STAFF REPORT

SHORELINE SUBSTANTIAL DEVELOPMENT PERMIT

Project No.:	SHL22-027
Description:	A request for a Shoreline Substantial Development Permit with SEPA Review for the installation of (2) new dock mounted personal watercraft (PWC) lifts, (1) new boatlift, relocation and permitting of (1) existing platform lift and permitting of (1) existing boat lift.
Applicant / Owner:	Dray Davick (Seaborn Pile Driving Company) / Samuel and Sarah Leclercq
Site Address:	4548 E Mercer Way, Mercer Island, WA 98040; Identified by King County Assessor tax parcel number 182405-9033.
Zoning District:	Single Family Residential (R-15)
Staff Contact:	Molly McGuire, Planner
Exhibits:	<ol style="list-style-type: none">1. Development Application, received by the City of Mercer Island on November 17, 20222. Development Plan Set, dated November 9, 2022 and received November 17, 20223. SHL01-007 Shoreline Exemption Permit Decision, dated March 13, 20014. SHL14-001 Shoreline Exemption Permit Decision, dated January 27, 20145. Project Narrative, received November 17, 20226. Revised SEPA Checklist, received November 17, 20227. No Net Loss Report prepared by Northwest Environmental Consulting, LLC, dated August

PROPOSED CONDITIONS

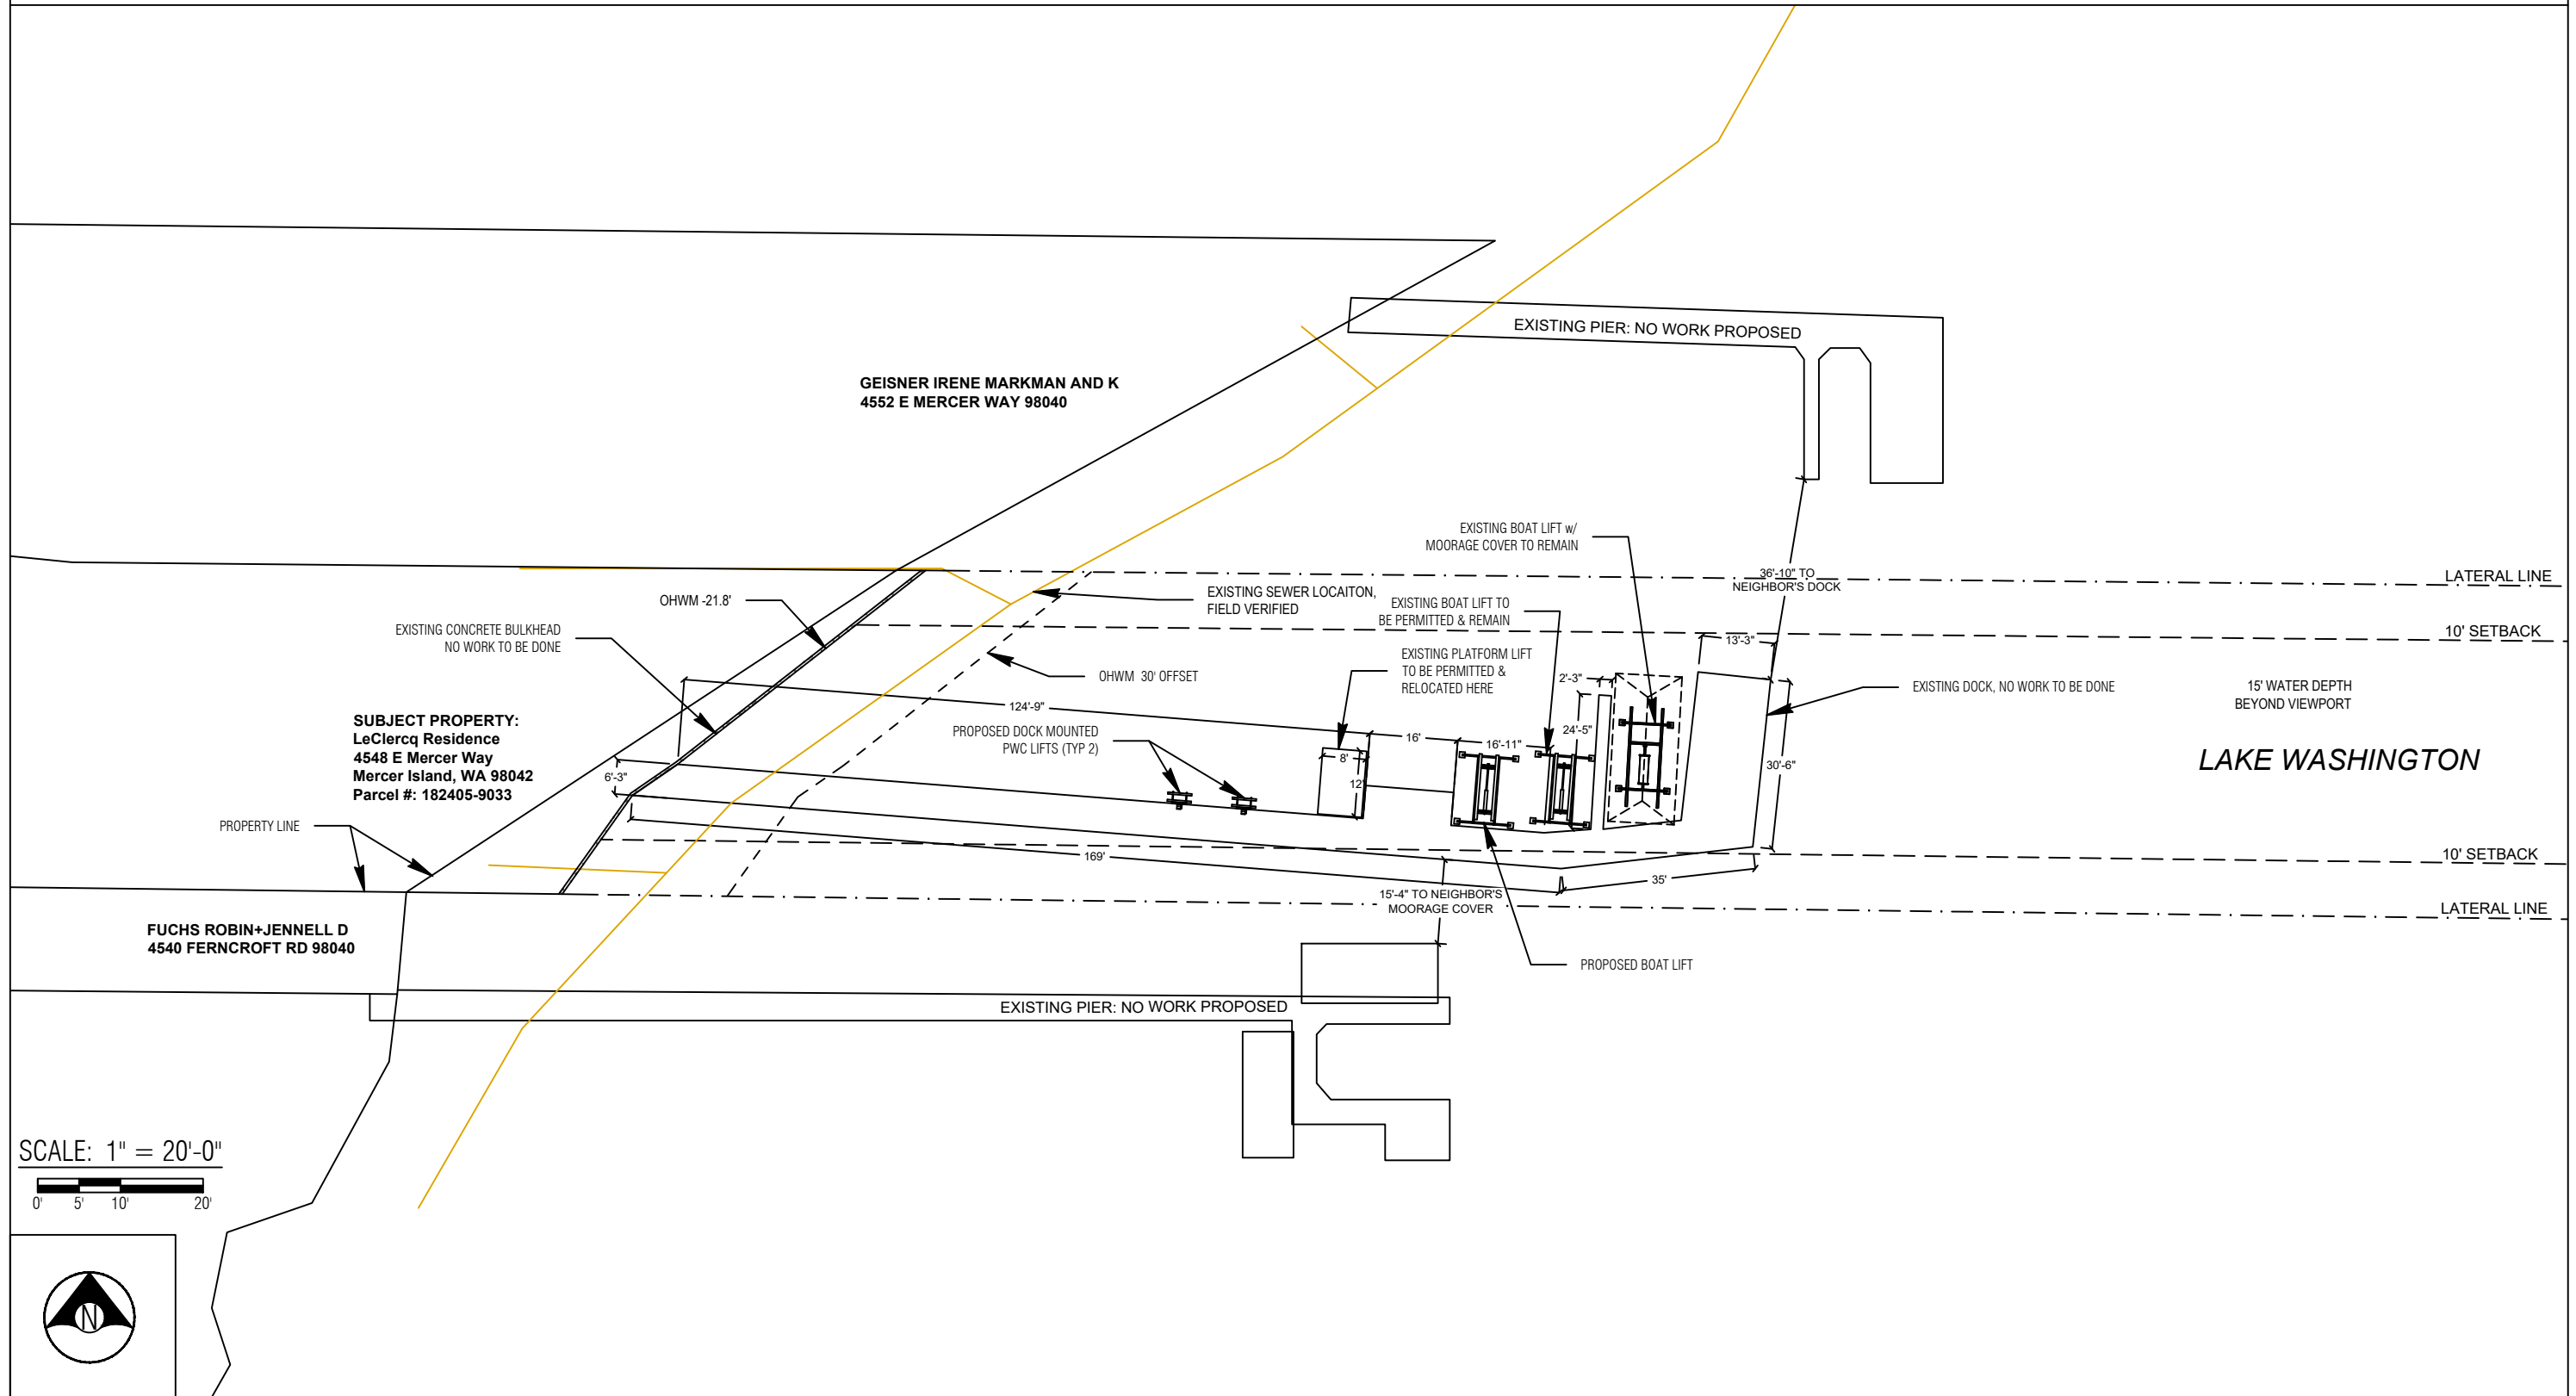
Staff Analysis: The subject property contains only one noncommercial, residential moorage facility (Exhibit 2, Sheet 3.0); therefore, this standard is met.

Staff Analysis: The existing pier is located less than 10 ft away from the south lateral line (Exhibit 2, Sheet 3.0). The pier was constructed prior to 1963, based on the City's online mapping system. The pier was previously repaired in 2001 via Shoreline Exemption permit no. SHL01-007 (Exhibit 3) and again in 2014 via Shoreline Exemption permit no. SHL14-001 (Exhibit 4). Pursuant to MICC 19.13.020(A), overwater uses and structures, and uses and structures 25 feet landward from the OHWM, which were legally created may be maintained, repaired, renovated, remodeled and completely replaced to the extent that nonconformance with the standards and regulations of this chapter is not increased. The pier was legally established, and no work is proposed on the existing pier through this permit.

Staff Analysis: The existing pier extends approximately 204 feet from the OHWM (Exhibit 2, Sheet 3.0). The pier was previously repaired in 2001 via Shoreline Exemption permit no. SHL01-007 and again in 2014 via Shoreline Exemption permit no. SHL14-001. Pursuant to MICC 19.13.020(A), overwater uses and structures, and uses and structures 25 feet landward from the OHWM, which were legally created may be maintained, repaired, renovated, remodeled and completely replaced to the extent that nonconformance with the standards and regulations of this chapter is not increased. The pier was legally established, and no work is proposed on the existing pier through this permit.

Staff Analysis: The existing pier is approximately 6 feet, 3 inches wide within 30 feet waterward from the OHWM (Exhibit 2, Sheet 3.0). The pier was previously repaired in 2001 via Shoreline Exemption permit no. SHL01-007 and again in 2014 via Shoreline Exemption permit no. SHL14-001. Pursuant to MICC 19.13.020(A), overwater uses and structures, and uses and structures 25 feet landward from the OHWM, which were legally created may be maintained, repaired, renovated, remodeled and completely replaced to the extent that nonconformance with the standards and regulations of this chapter is not increased. The pier was legally established, and no work is proposed on the existing pier through this permit.

Staff Analysis: The existing pier is approximately 13 feet, 3 inches wide at the widest point greater than 30 feet waterward from the OHWM (Exhibit 2, Sheet 3.0). The pier was previously repaired in 2001 via Shoreline Exemption permit no. SHL01-007 and again in 2014 via Shoreline Exemption permit no. SHL14-001. Pursuant to MICC 19.13.020(A), overwater uses and structures, and uses and structures 25 feet landward from the OHWM, which were legally created may be maintained, repaired, renovated, remodeled and completely replaced to the extent that nonconformance with the standards and regulations of this chapter is not increased. The pier was legally established, and no work is proposed on the existing pier through this permit.
